File No. 4668

November 7, 2014

Subject: Design Phase Review of Building 1, Maine Wharf - Fire Protection Systems

DRAWING NO.:  
**FP-1.2**

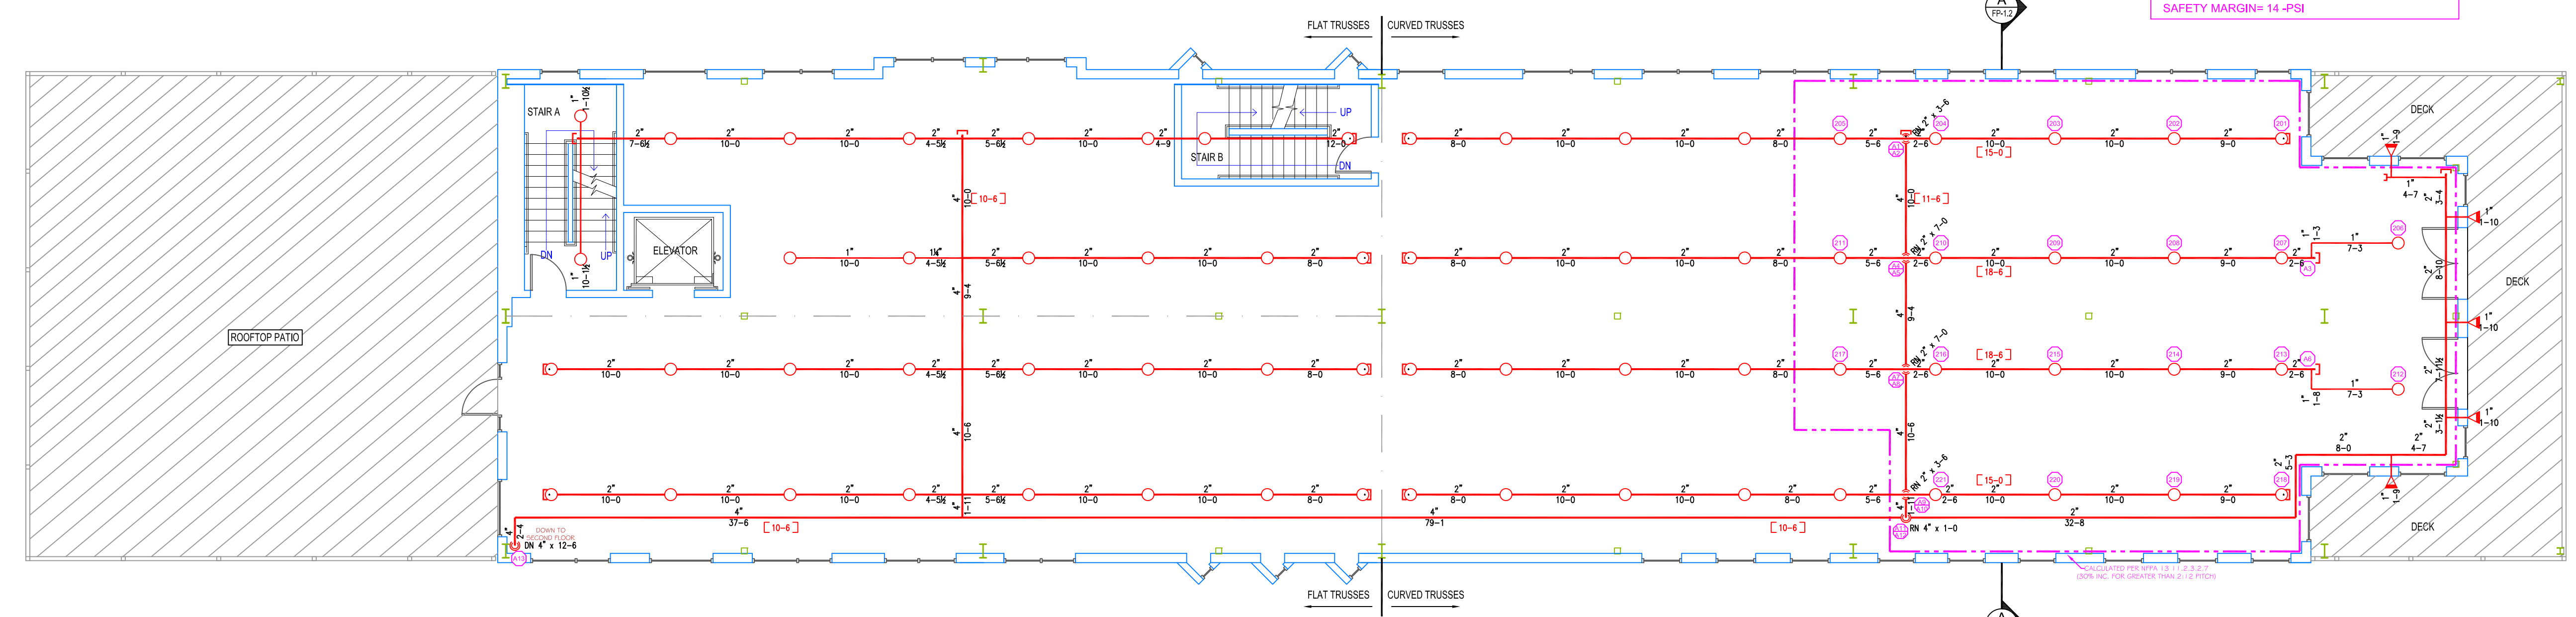
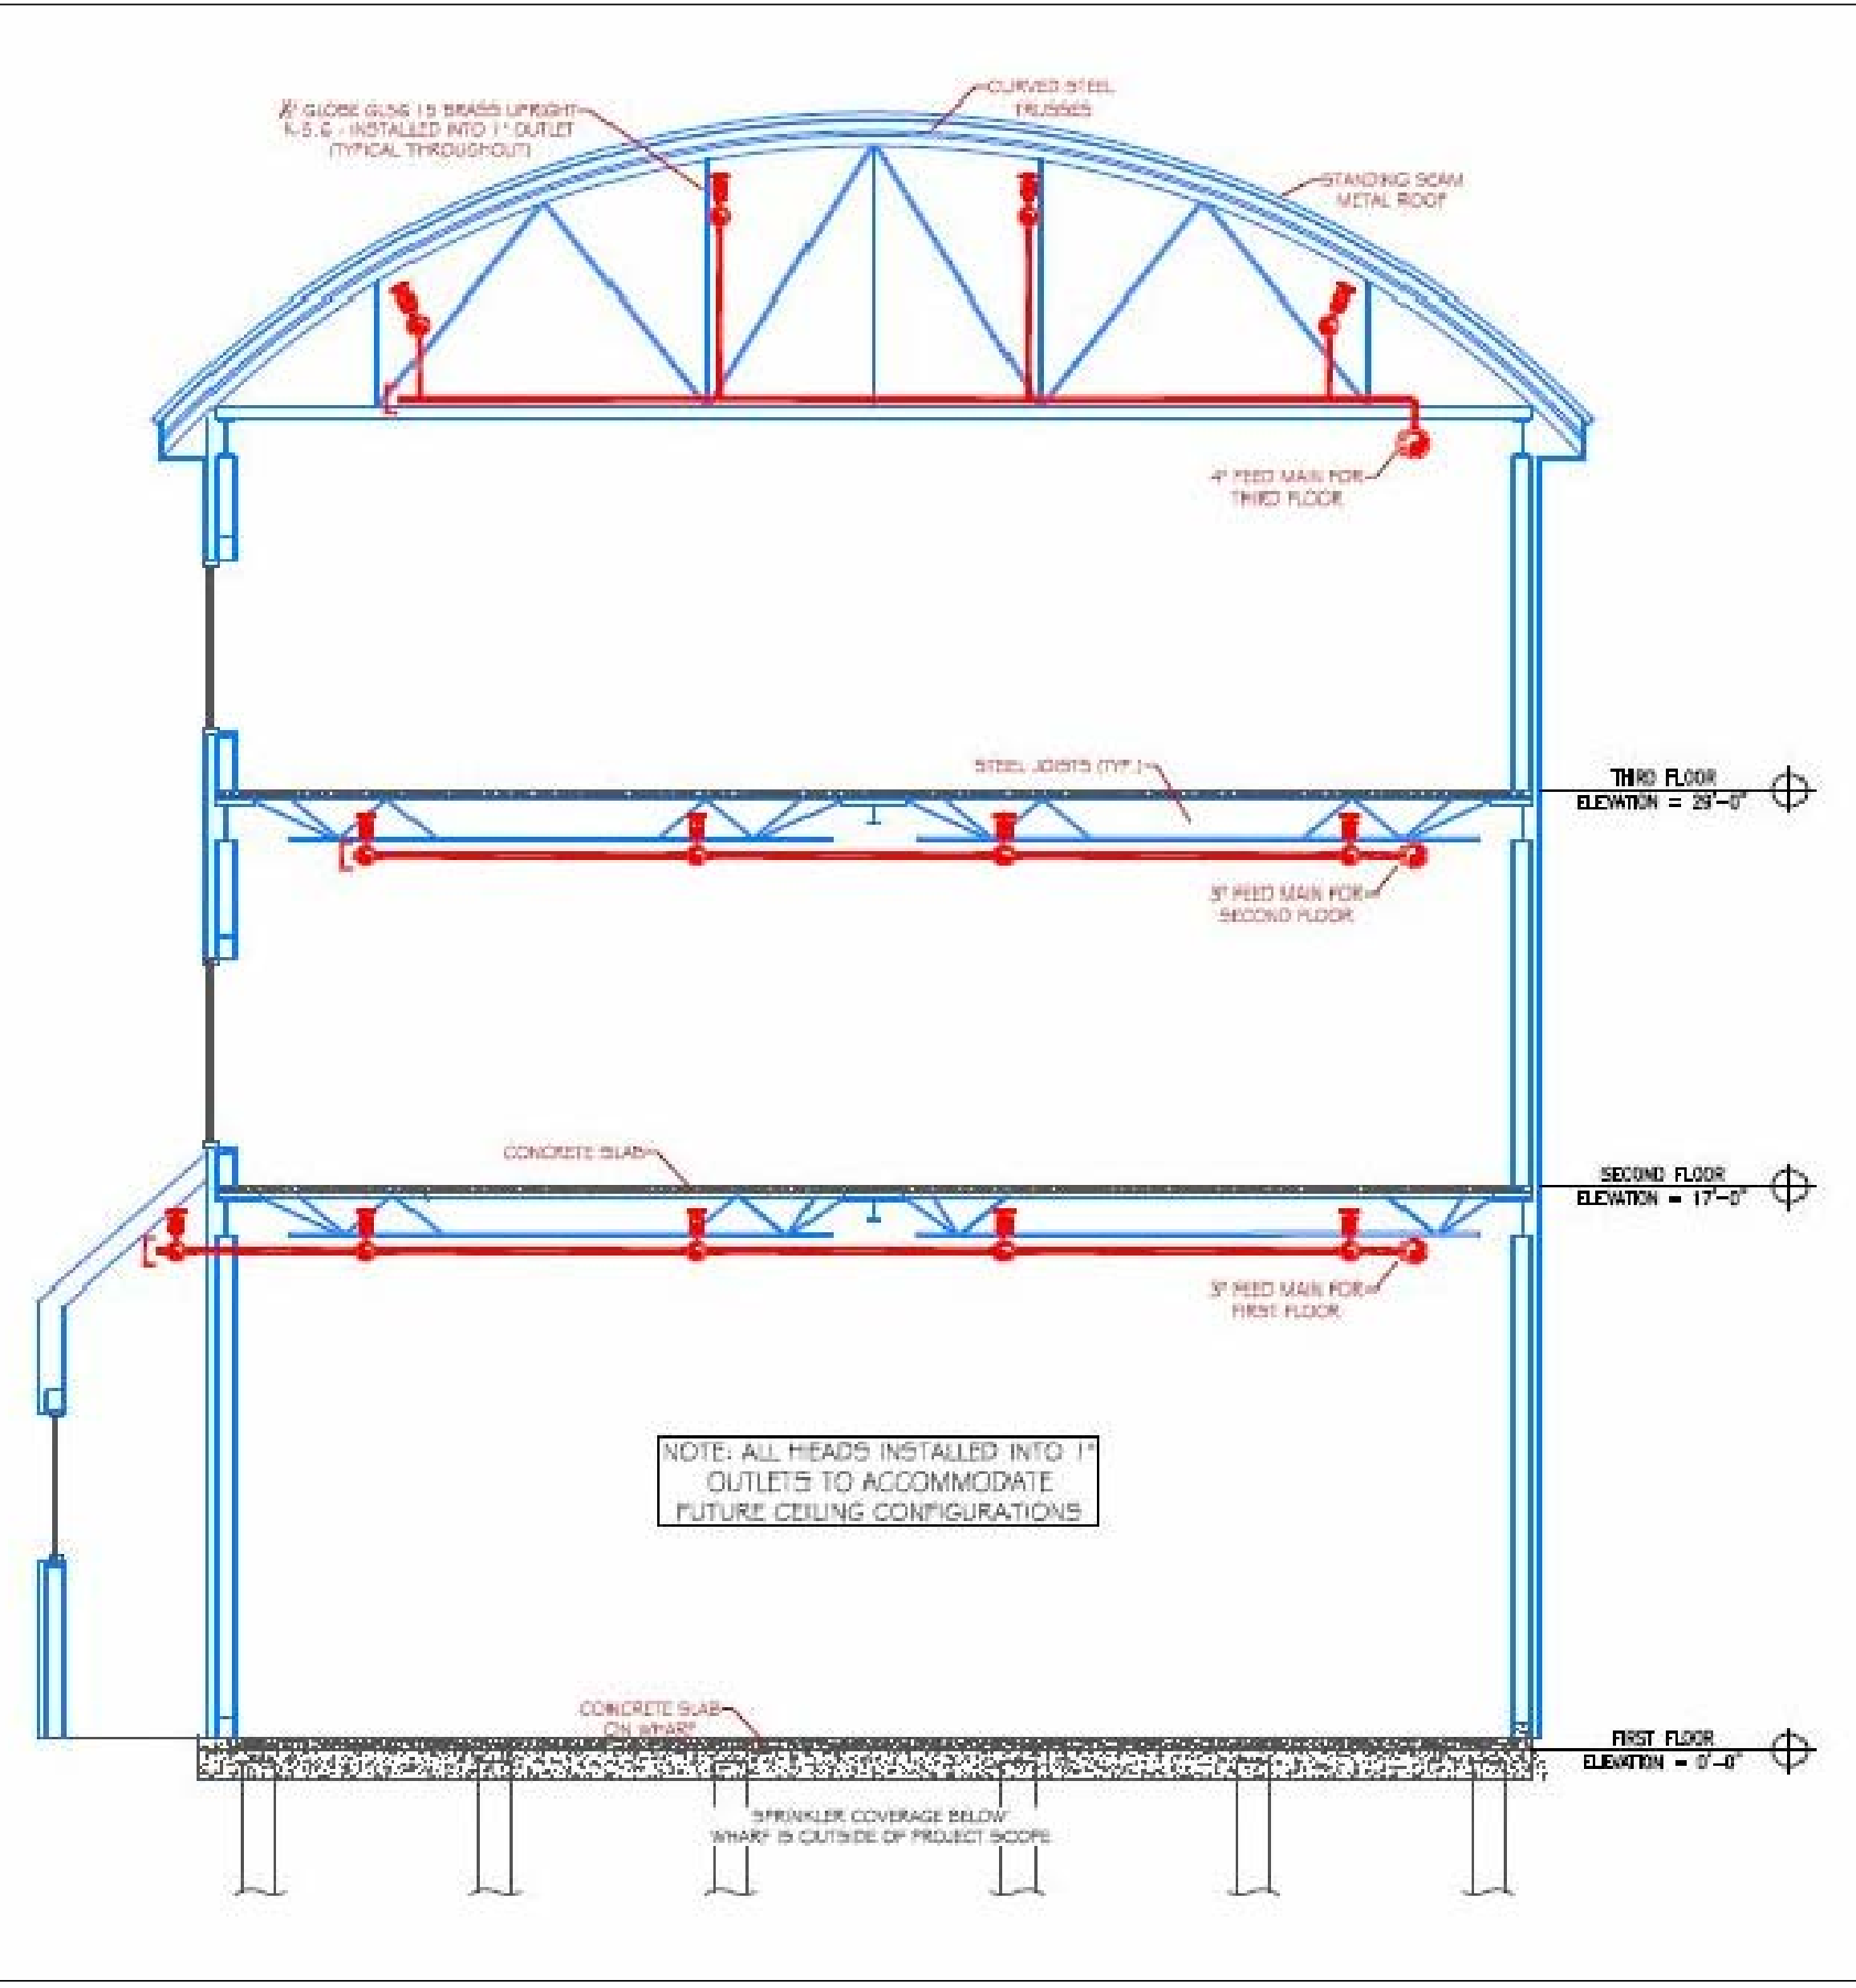
- In accordance with NFPA 1, 2009 Edition, Section 28.1.6.3.4, supply piping for standpipes on piers and bulkheads shall be sized for the minimum flow rate for Class II systems. NFPA 14, Section 7.10.2.1 outlines minimum flow rates for Class II systems. In order to review the pipe sizing for the hose connection, we need to review hydraulic flow calculations to determine if the pipe size is suitable. It is our understanding that High Tech Fire Protection will submit standpipe hydraulic calculations for review.

- NFPA 14, Section 7.3.2.2 outlines the requirements for hose connection locations and states that they shall be provided in approved locations, where required by the local fire department or the AHJ. *FIREPRO*®'s approval of these locations is dependent on approval by the AHJ. It is our understanding that High Tech Fire Protection has had discussions with the Portland, Maine Fire Department in regards to approval of the location of the 2 ½ inch standpipe hose connections. High Tech Fire Protection shall provide copies of the emails stating that the AHJ has accepted the hose connection locations as shown on the design drawings.
